THE THANET EXTENSION OFFSHORE WIND FARM ORDER

Summary of Oral Submissions made at ISH9 and comments on the Applicant's dDCO submitted on behalf of the Port of London Authority and Estuary Services Limited
(Rule 8 letter 18 December 2018)

Unique Reference Number	EN010084
Document Ref.	PLA 17 / ESL 17
Author	Winckworth Sherwood LLP
Date	29 April 2019

Sea Zones Plan – Reduction in red line boundary

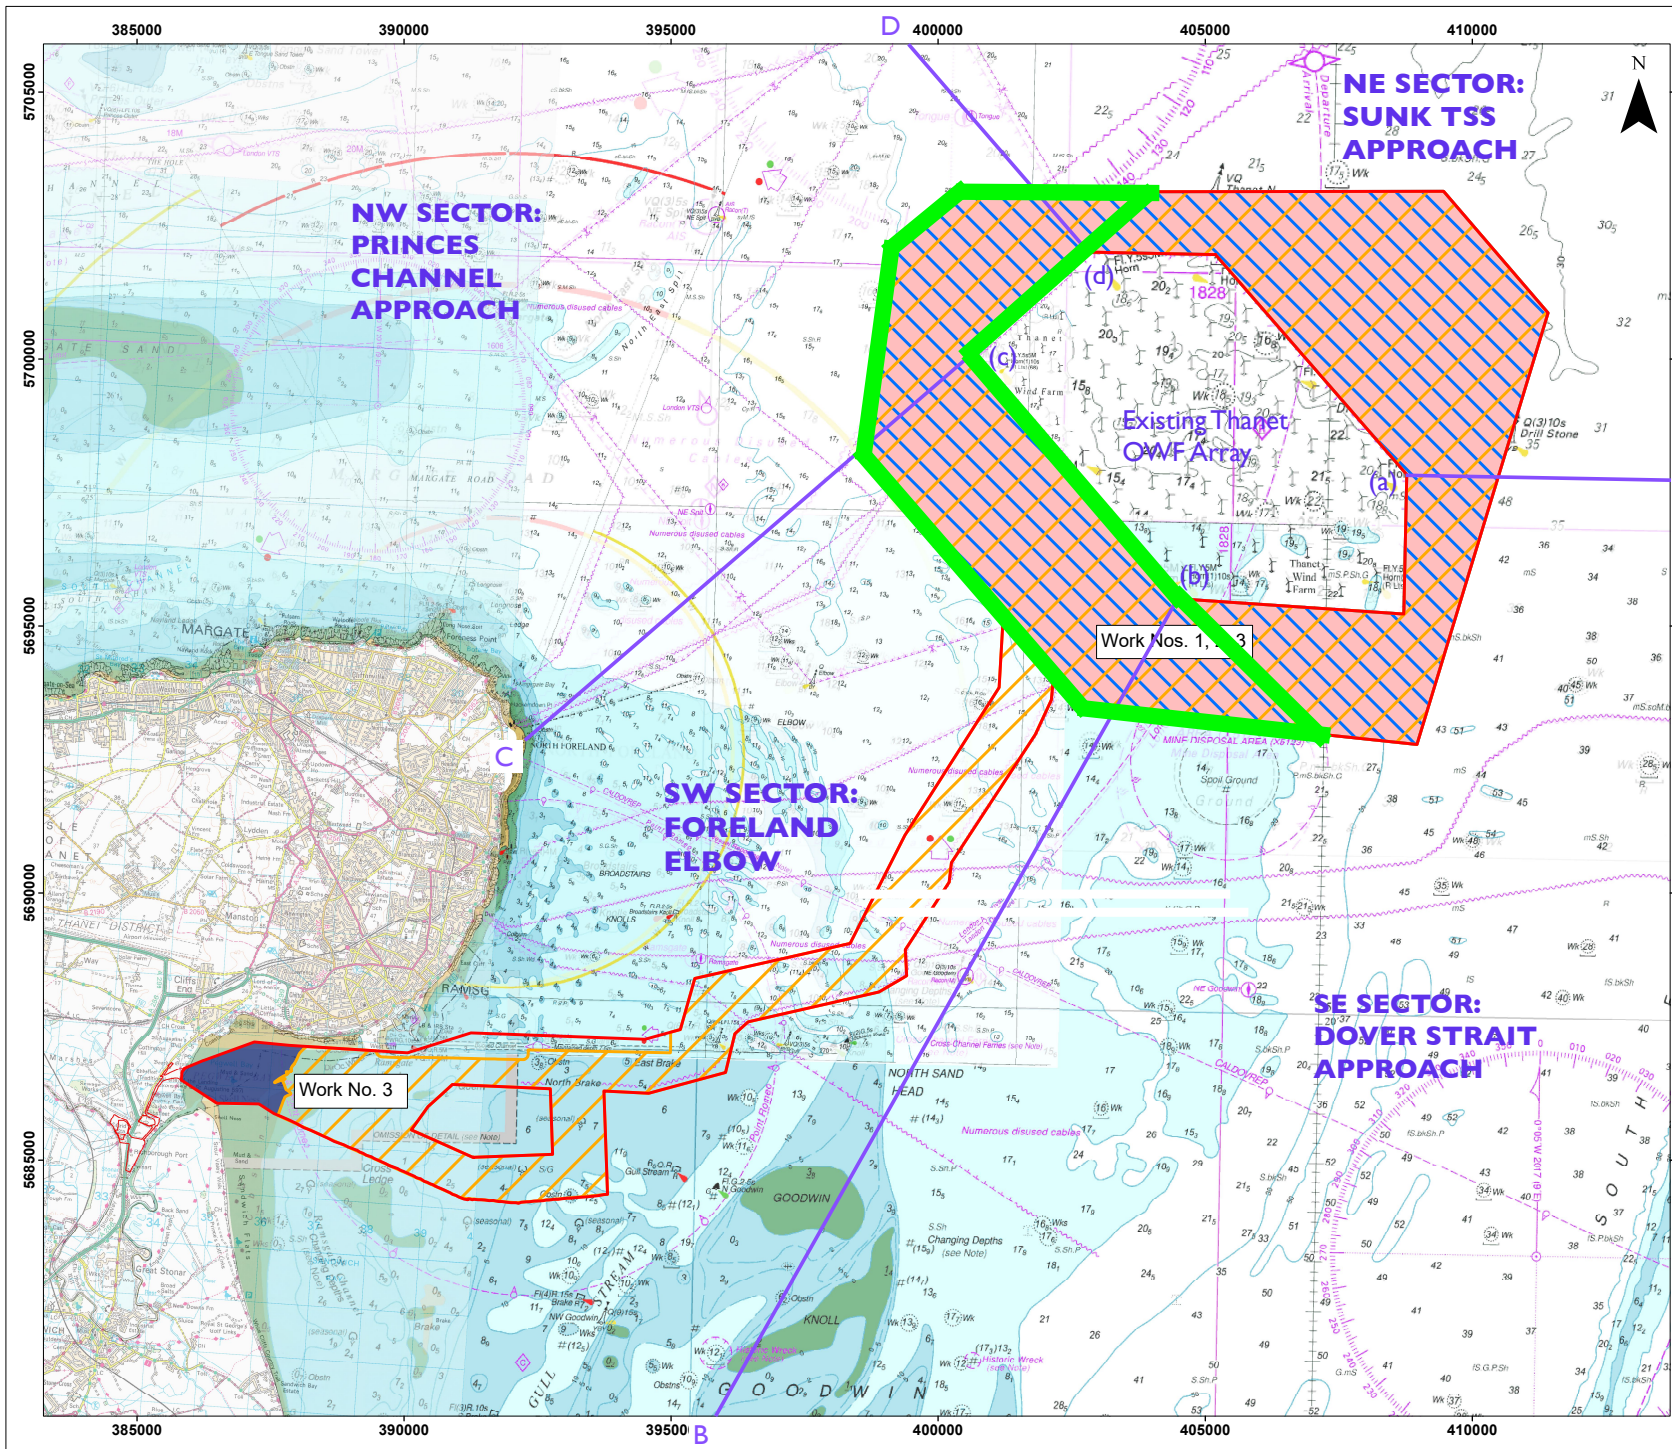
- 3.3 Finally, there is a lack of clarity about the permitted uses of the SEZ during construction and those during operation.
- 3.4 As it stands, the SEZ does not achieve the same outcome as the PLA and ESL’s requested amendment to the Red Line Boundary (“RLB”). Ms Dillistone suggested that a possible solution would be to have a complete prohibition on activities within the SEZ but with some limitations, for example to allow for a cabling corridor. The PLA and ESL have no in principle objection to cable installation.

- 3.8 Ms Dillistone therefore suggested that a more effective drafting solution would be to clearly identify that all activities – including those linked to construction, operation, maintenance and decommissioning – are excluded within the SEZ, but provide an exception for the laying of a specified number of cables within an identified corridor that are needed to connect the wind farm. Ms Holgate agreed to consider this proposal and to contact Ms Dillistone about drafting changes to the dDCO in advance of Deadline 5.
